Diary against Annex Website Submissions for job #4995 SSD 4949-2011 Music Festival Royal Randwick Racecourse

Objection per attached letter based on insufficent traffic management plan

I object to the development application SSD 4995-2011 – Future Music Event on 10 March 2012.

TCP No. 4

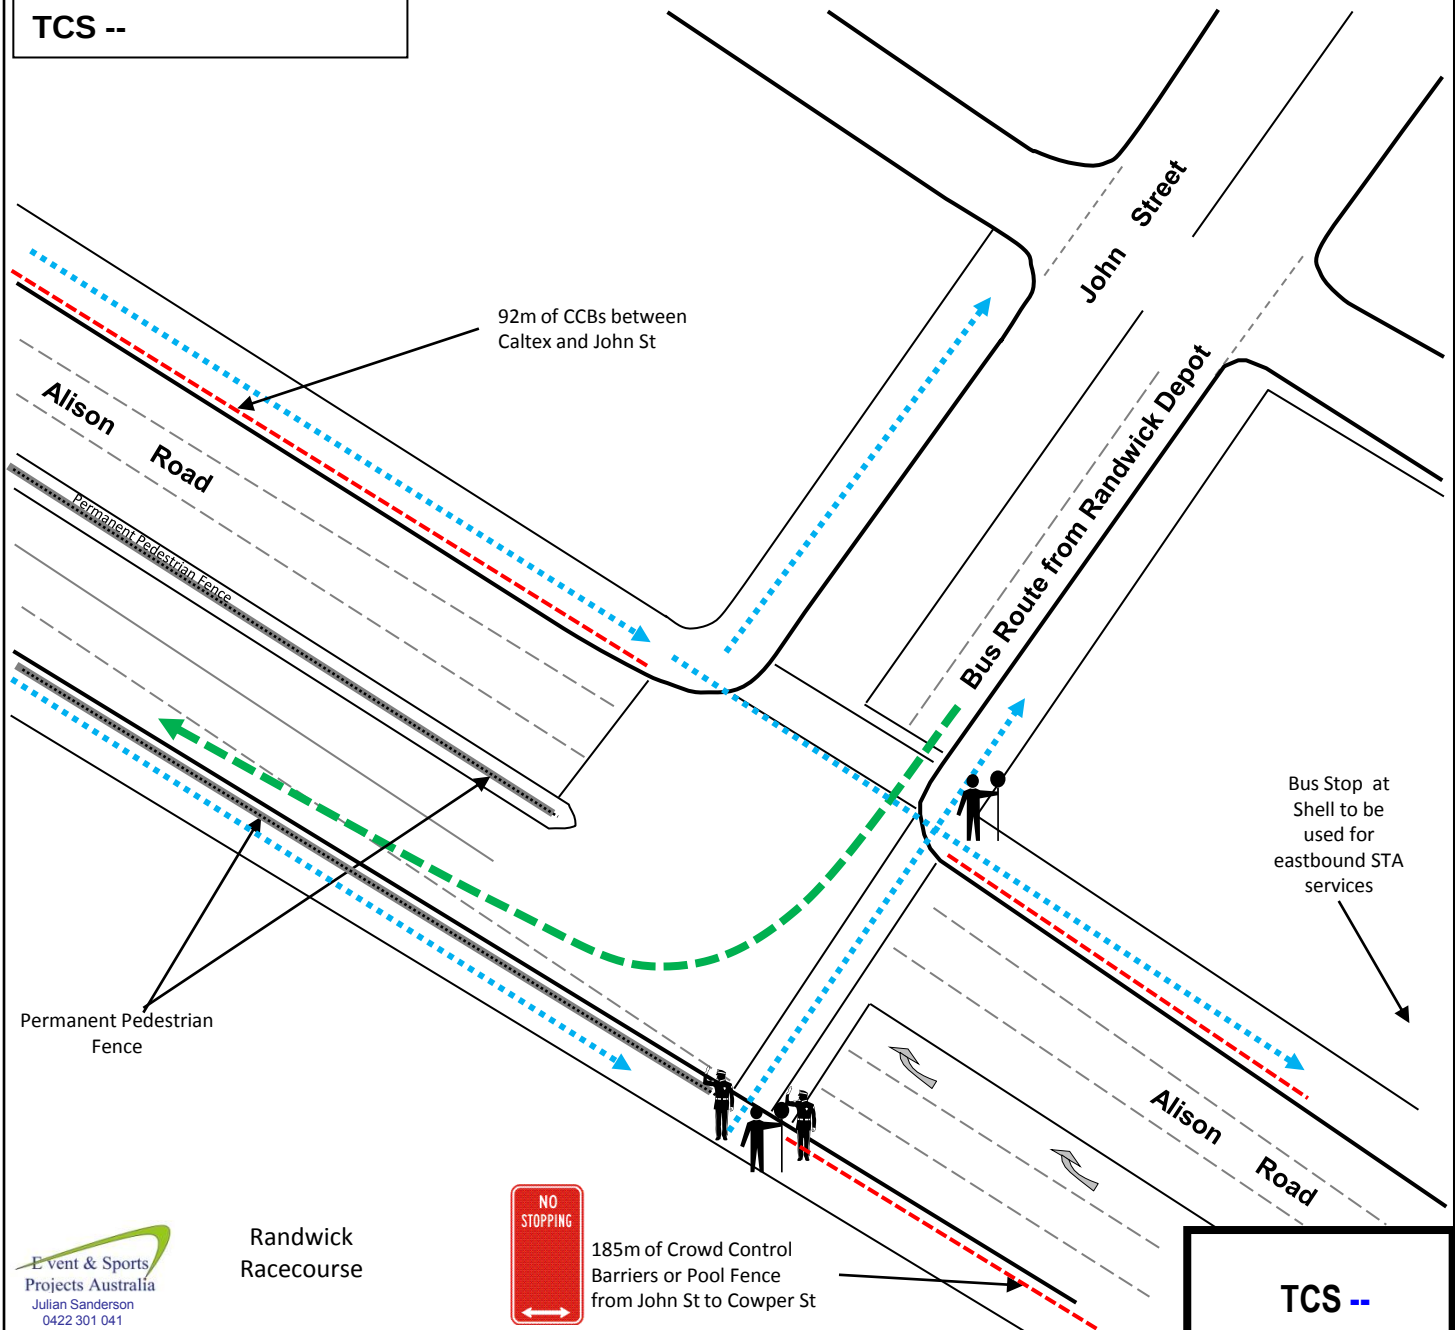
• Firstly, it necessary to direct attendees who drive east along Alison Road past the residential streets leading off Alison Road (being John, Cowper and Prince) up to the turn-off just after gate 8 of the Racecourse. Accordingly, I suggest that left turns from Alison Road into John (TCP4), Cowper (TCP5) and Prince Street be closed, (buses excepted) between midday and 5pm (this being the ingress period). Similar arrangements already exist to the area west of the Racecourse (left turns from Anzac Parade into Carlton, Goodwood Streets – per TCP19& TCP20 for the egress period).

2012 Future Music Festival**TCP No. 8a****Wansey Rd / Infield Road to Event Parking Randwick (Gate 10)****Ingress****Ingress: 11:30am – 5:00pm****Peak: 12:30am – 2:30pm****Staff From 6am**

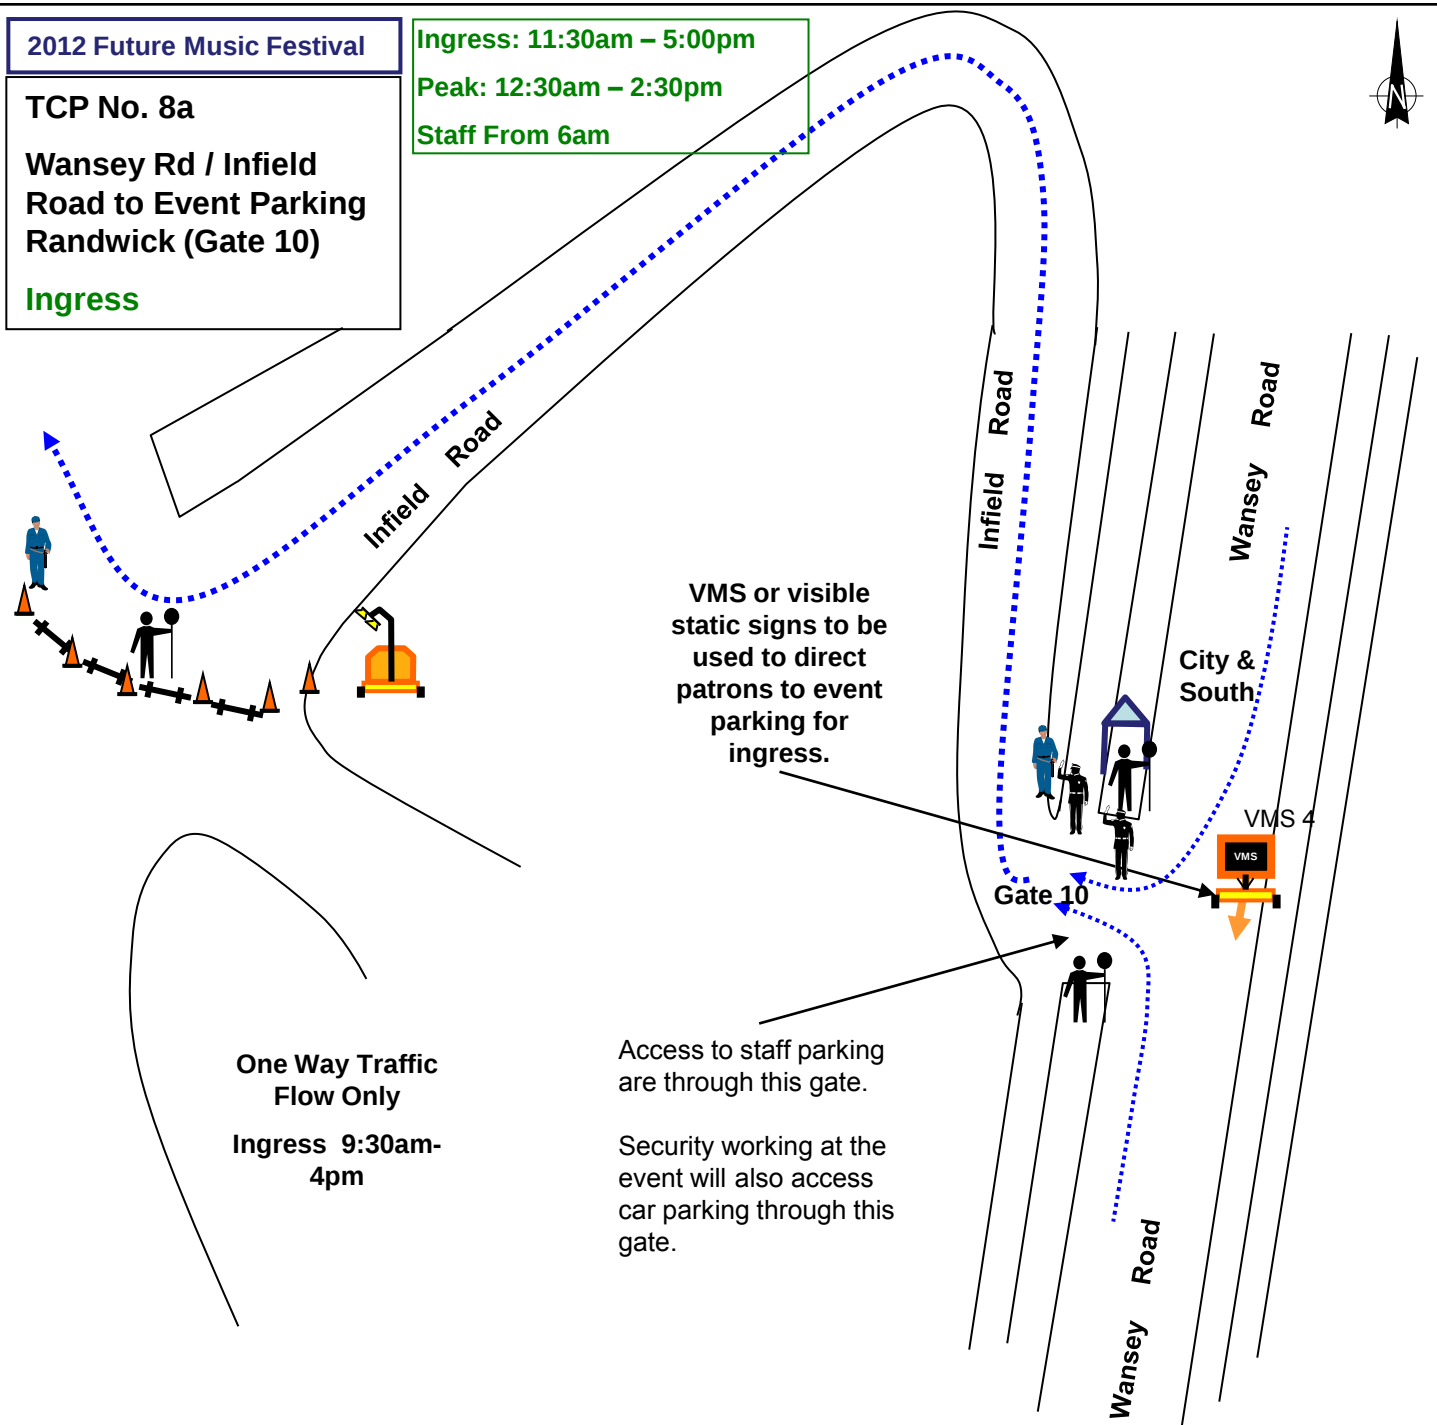
For TCP 8 to be effective, this being the only entrance to 'on-field' parking for attendees who drive, a majority drive east along Alison Road (being the 'primary frontage' of the Racecourse):

Attendees who drive would then continue south-east along Alison Road and via variable message signs (on Alison Road) would be directed to turn right into Wansey Road for event parking per TCP8a - ingress. At the very least, several variable message signs on the east side of Alison Road (between Doncaster Avenue and Prince Street) should direct attendees to "get in right lane for free event parking" (first message) and "turn right at Wansey Road for event parking" (second message) or similar.
